DRB CASE ACTION LOG - BLUE SHEET

Project #: 1003421 Application #: 12DRB-70175
 Project Name: Renaissance Center Application #: 12DRB-70188
 Agent: Tioma West Phone #:

DRB Application No.: 04DRB-01306 (P&F)	Project # 1003421
Project Name: RENAISSANCE CENTER	
Agent: Precision Surveys Inc.	Phone No.: 856-5700

RE: Renaissance Center Tracts 1B1E, 1B1D & 1A2/minor plat

Plat of
Tract 1A-2-A
Renaissance Center
Albuquerque, Bernalillo County, New Mexico
August 2004

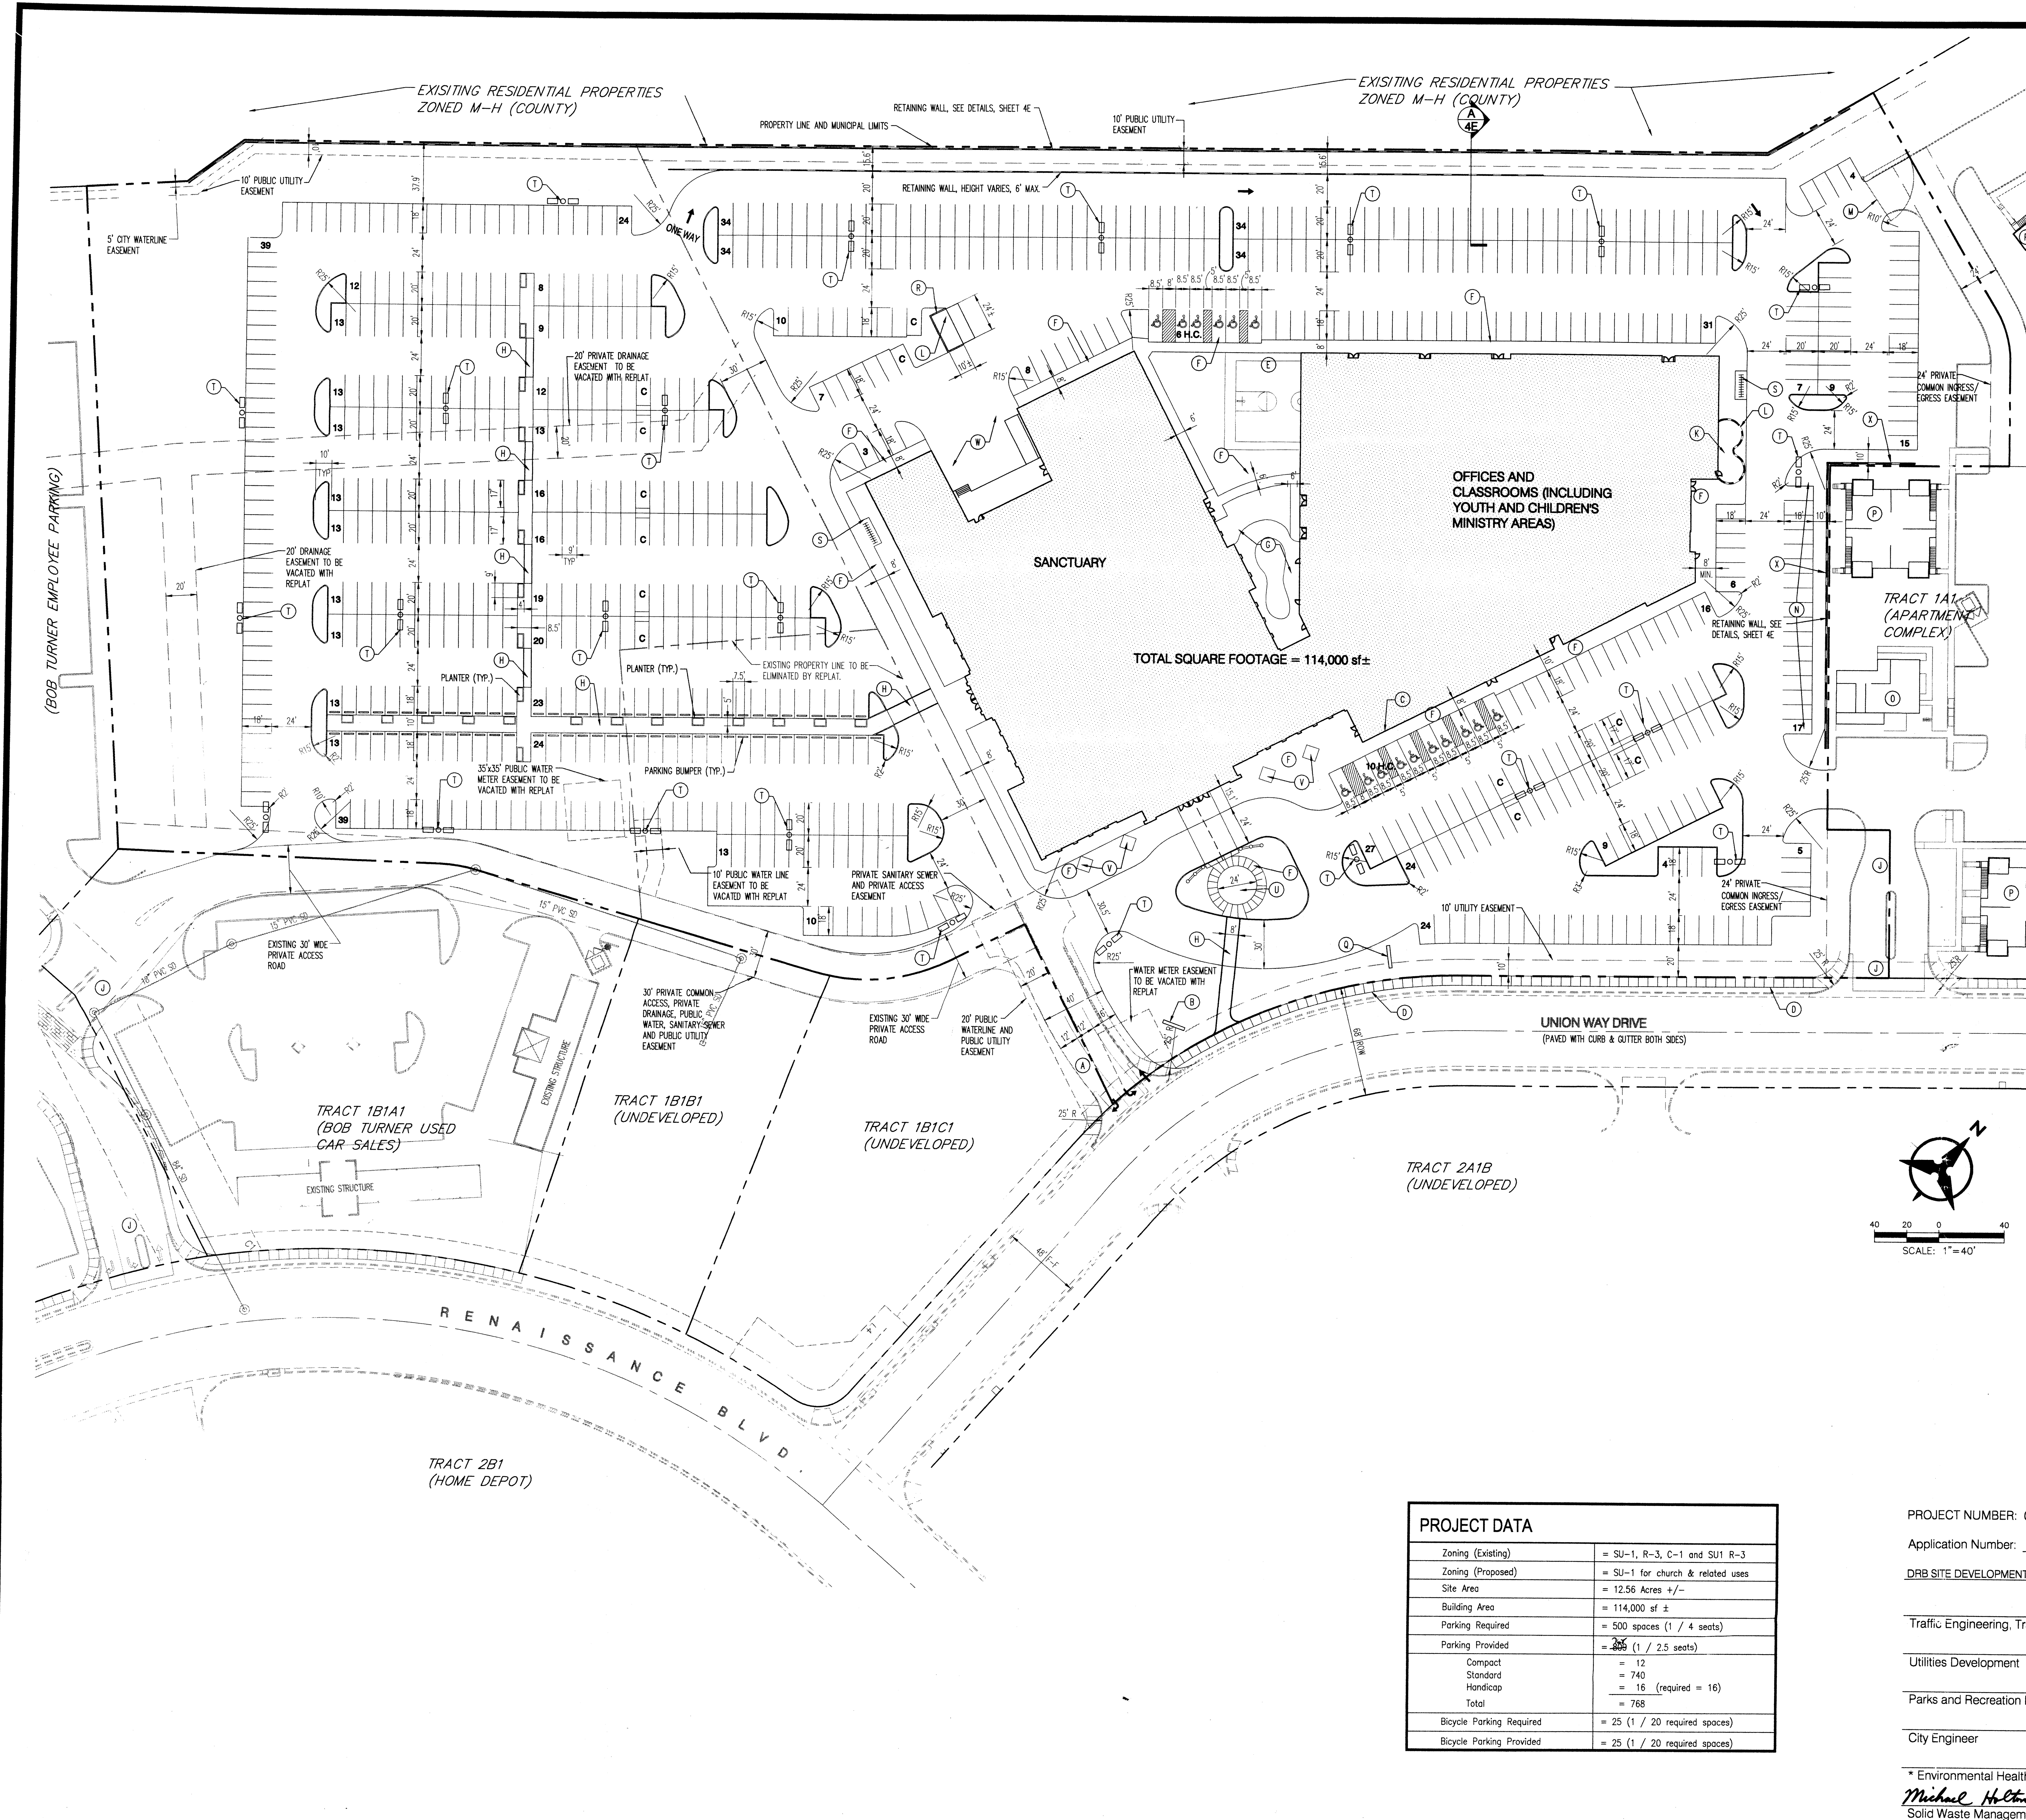
UTILITIES: either show SAS easement on plat (SAS easement recorded 9/25/03) or process a Release of Easement.

Plat of
Tracts 1A-2-A-1, 1A-2-A-2, and 1A-2-A-3
Renaissance Center
 Albuquerque, Bernalillo County, New Mexico
 May 2012

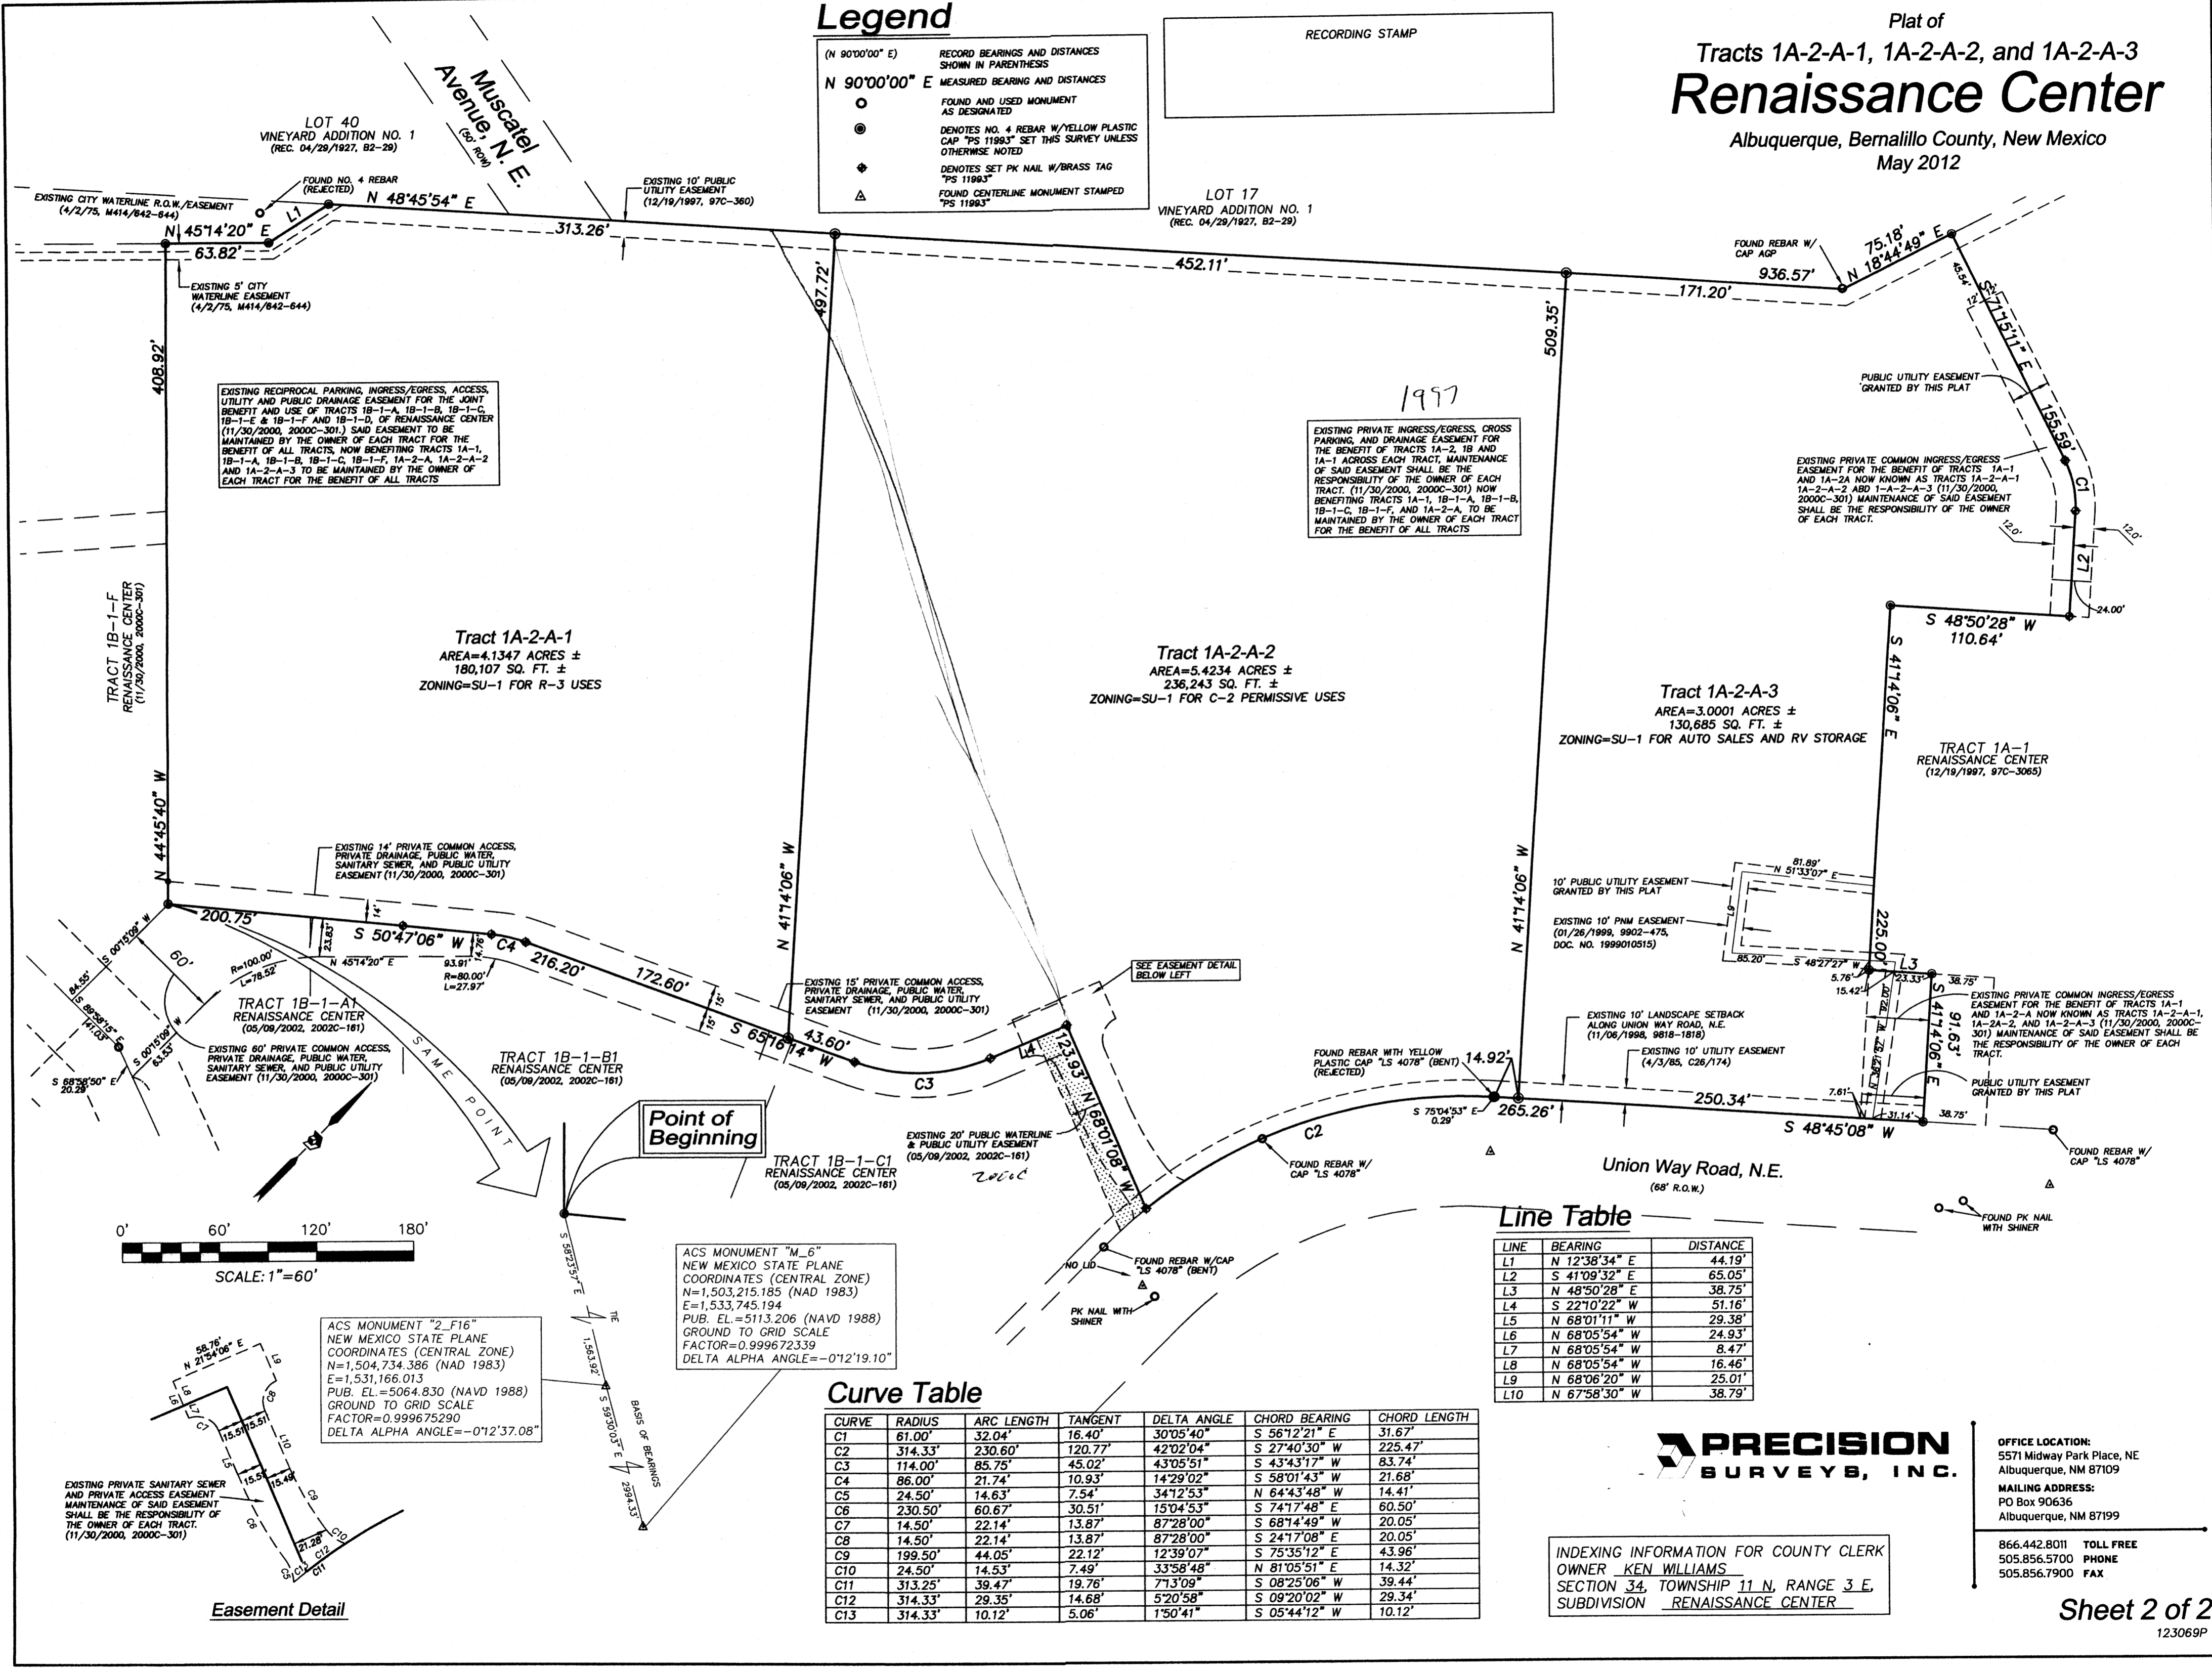
CITY ENGINEER / AMAFCA: address comments - Add Title 1-10-2A-3 to Working Note as beneficiary
